City of Albuquerque Stormwater Construction Site Inspection Report

Project Name and Location	Spanish Trails Rehab Sinks Renaissance & Commercial		
Site Contact Name & Agency	OSCAR DEYNEZ	Contact Phone #/ E-mail	See File
Date of Inspection	6-13-17	Start/End Time	9:20/
Inspector Name, COA Dept.	Curtis Cherne, Stormwater Quality		
Inspector Phone / E-mail	505-924-3420/ccherne@cabq.gov		
Inspector Qualifications	Qualified Compliance Inspector of Stormwater- Stormwater One		
Describe Present Phase of Construction	Stabilizer		
Type of Inspection:	<input checked="" type="radio"/> Regular • During storm event • Post-storm event (> 0.5 inch) • 311 / Complaint Response • Follow-Up

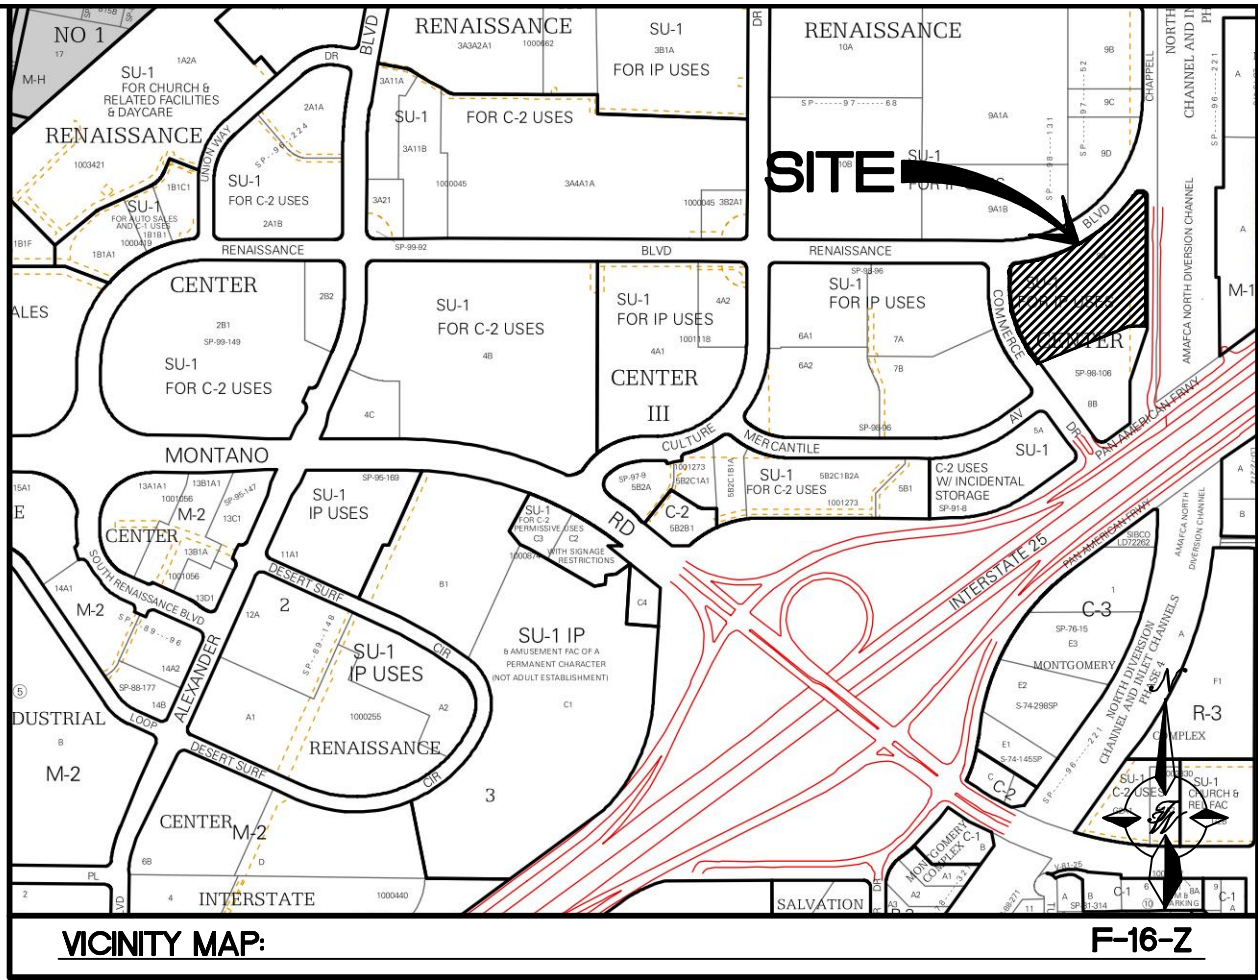
Oscar,
Thanks for taking the time to speak with me today. I went to see you after I was done and you weren't there.
The track-out pad on Renaissance needs maintenance.

- Entrance / Track-Out minor track-out, extreme rear maintenance
- Sediment Controls / Silt Fence, Check Dams, Waddles, etc. Silt fence not buried north edge east of entrance
Sediment in street - place wattle in corner
side walk control discharge sediment into street (banned)
- Erosion Controls / Mulch, Seed, 1 dense concrete wash-out next to bin
- Housekeeping/Pollutant Controls 1 corner pollution middle of site
1 " " SW area of site
- Debris/Pollutants/Sediment in MS4 _____
- Notes Gutter on curb perimeter needs to be swept
Start 100' south of intersection the east and left turn lane

1. The construction exit needs maintenance and there is track-out.
2. There was sediment in the Renaissance and Commerce streets. Sweep.
3. One large and a couple smaller instances of cement pollution. Please place in wash-out bin.
